File no: MC-10-1711

17 November 2010

Re: Part 3A Major Development Project - Hewlett Packard Data Storage Project, Eastern Creek (MP 10_0142)

Drawing Title
ARCHITECTURE
SITE PLAN - GATE HOUSE

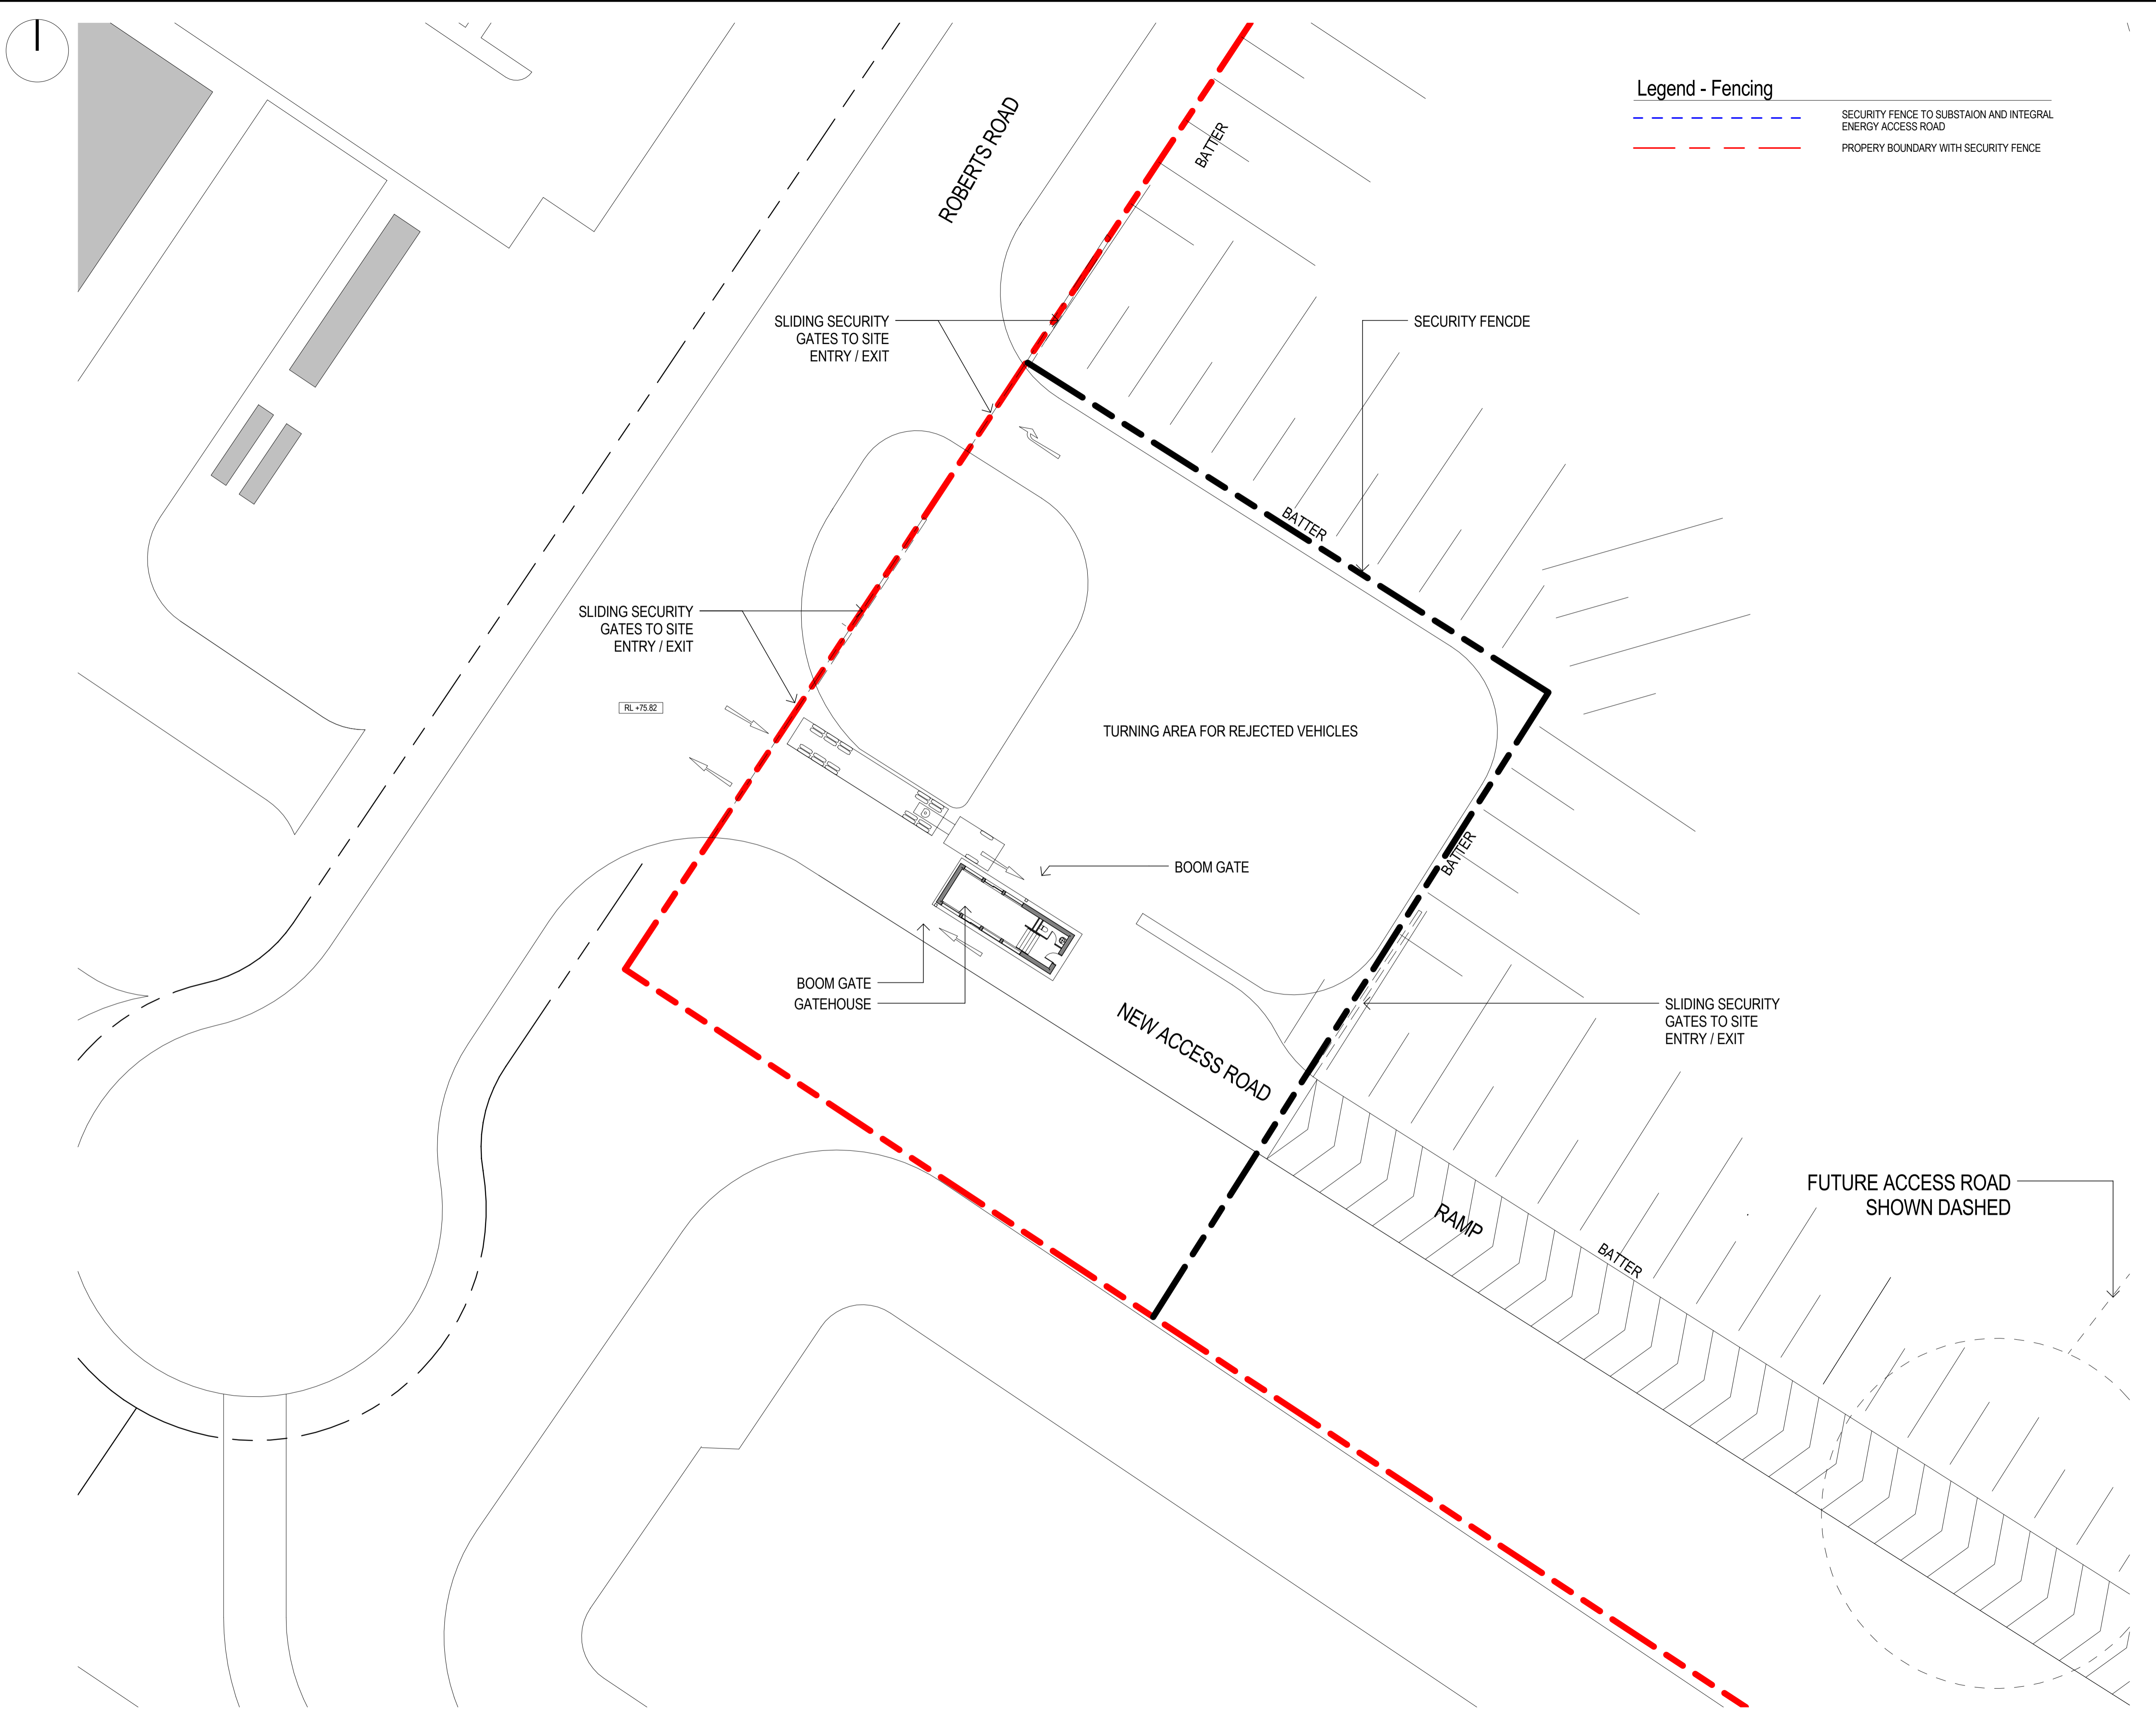
Provision is to be made for a 4m wide vehicular truck maintenance access way along the southern boundary and south-eastern splay boundary between the 2 detention basins with associated drainage easement in favour of Council and a right of way in favour of Council and Integral Energy. This is discussed further under the Stormwater Drainage and Civil Works heading at points (j), (k) and (l) of this letter.

- (j) The electrical switching yard is to be set back sufficiently from the southern and the south-eastern splay boundary to provide a **4 m wide vehicular truck maintenance access way between the two detention basins for Council**. This will also provide maintenance access for the pipeline that is proposed to be under this access way from the upper detention basin to the discharge point.

- (k) The access way is to be sealed to Integral Energy requirements from Roberts Road to at least the Switching Yard.
 - (l) The access way is to be a minimum of 4 m wide and covered by a drainage easement in favour of Council and a right-of-way in favour of Council and Integral Energy. Any fencing is to be set back a minimum of 4 m from the southern and the south-eastern splay boundary.
